**WELWYN HATFIELD BOROUGH COUNCIL
EXECUTIVE DIRECTOR - PLANNING, PUBLIC PROTECTION AND GOVERNANCE**

DELEGATED APPLICATION

Application No: 6/2019/2264/HOUSE
Location: 8 Orchard Close Cuffley Potters Bar EN6 4QD
Proposal: Erection of single storey front extension
Officer: Mr A Commenville

Recommendation: Granted

DRAWING NAME		Scale (@ A3) 1 : 100	REV
PROPOSED PLANS			P10

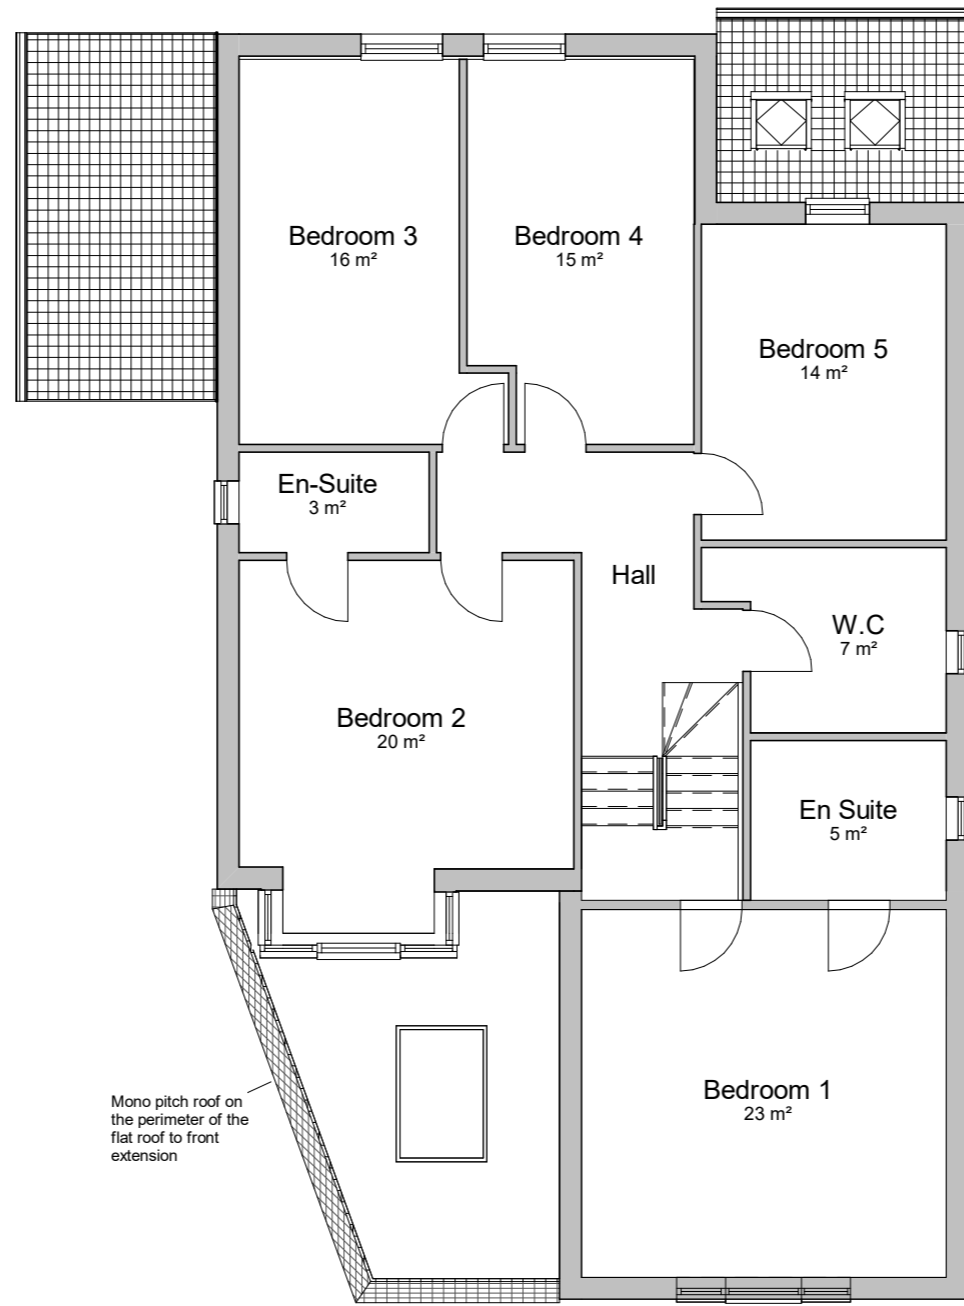
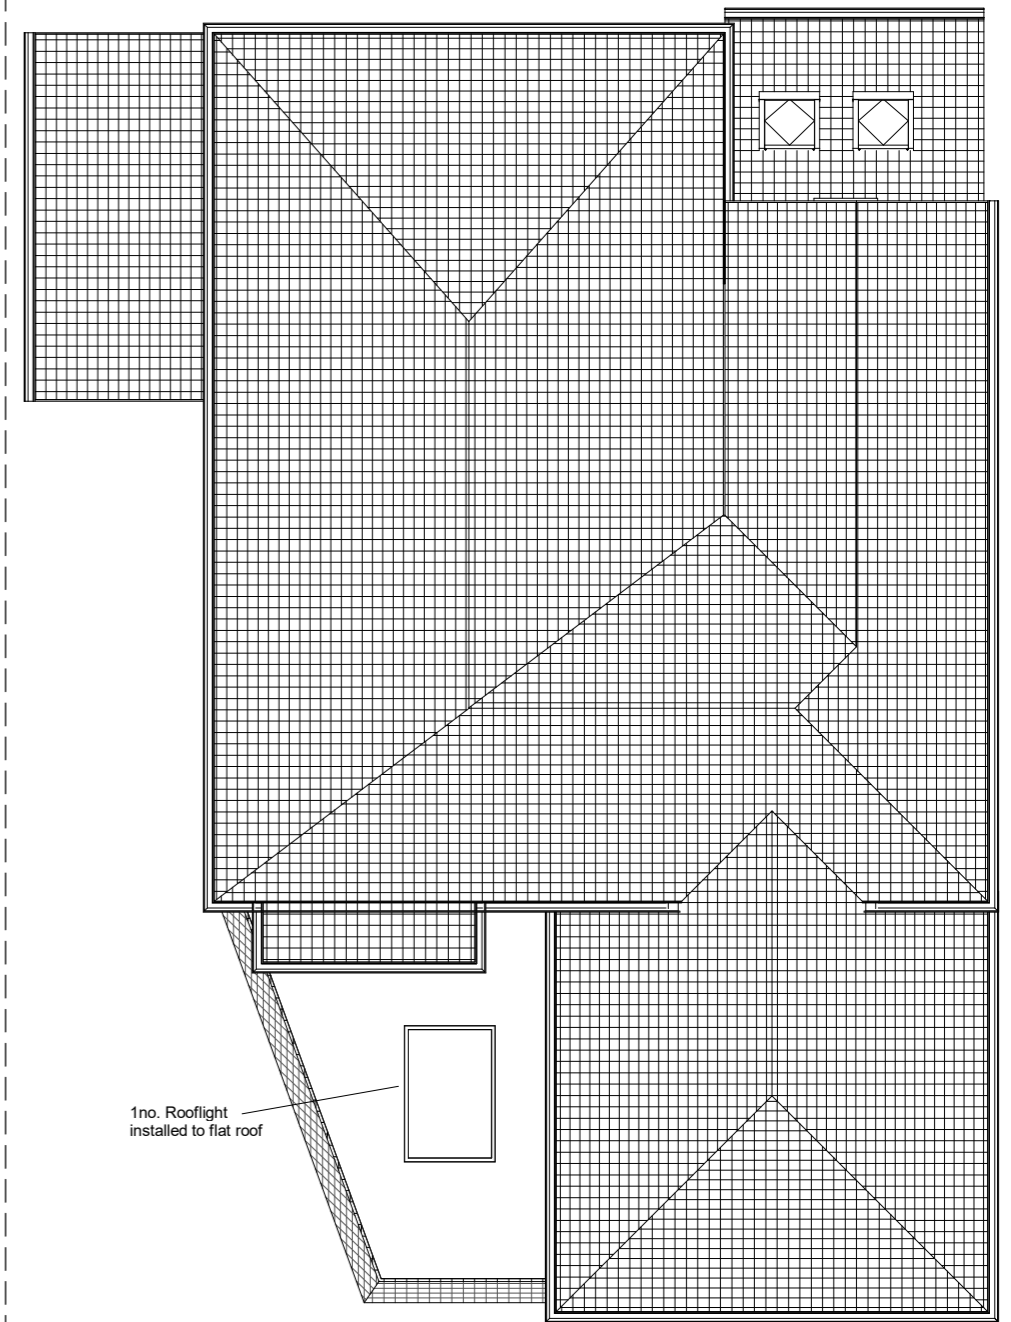
Comment (if applicable):	
Would the development reflect the character of the area?	
<input checked="" type="checkbox"/> Yes <input type="checkbox"/> No	
<p>Comment (if applicable): It is noted that the proposed ground floor front extension would add a reasonably significant amount of bulk and massing to the dwelling.</p> <p>However, the impact of the ground floor extension would mainly be due to the land sloping down to the front of the dwellinghouse. Furthermore, the front extension would have a limited depth and be flush with the existing front elevation wall. A 1.35 metre gap would be maintained between the flank elevation of the ground extension and the garage flank elevation at No. 7 Orchard such that the resultant dwelling would not appear cramped within its plot. Having regard to the above considerations, it is overall considered that the proposal would respect the scale and proportions of the existing dwelling and would not harm the character or appearance of the dwelling and surrounding area.</p> <p>The streetscene features a mix of size, design and styles of dwellings which gives an element of flexibility to proposals such that the impact of this proposal upon the street scene would be acceptable. The resultant dwelling would not appear incongruous within the street scene. The proposed materials would match those existing.</p> <p>This proposal thereby accords with Policies D1 and D2, of the District Plan, the Supplementary Design Guidance and the NPPF.</p>

Comment (if applicable): The proposed plans indicate a resultant 5-bedroom dwelling. The site benefits from a large frontage which would provide sufficient space for adequate provision of on-site car parking and the proposal would retain the garage. As such, no objections are raised.
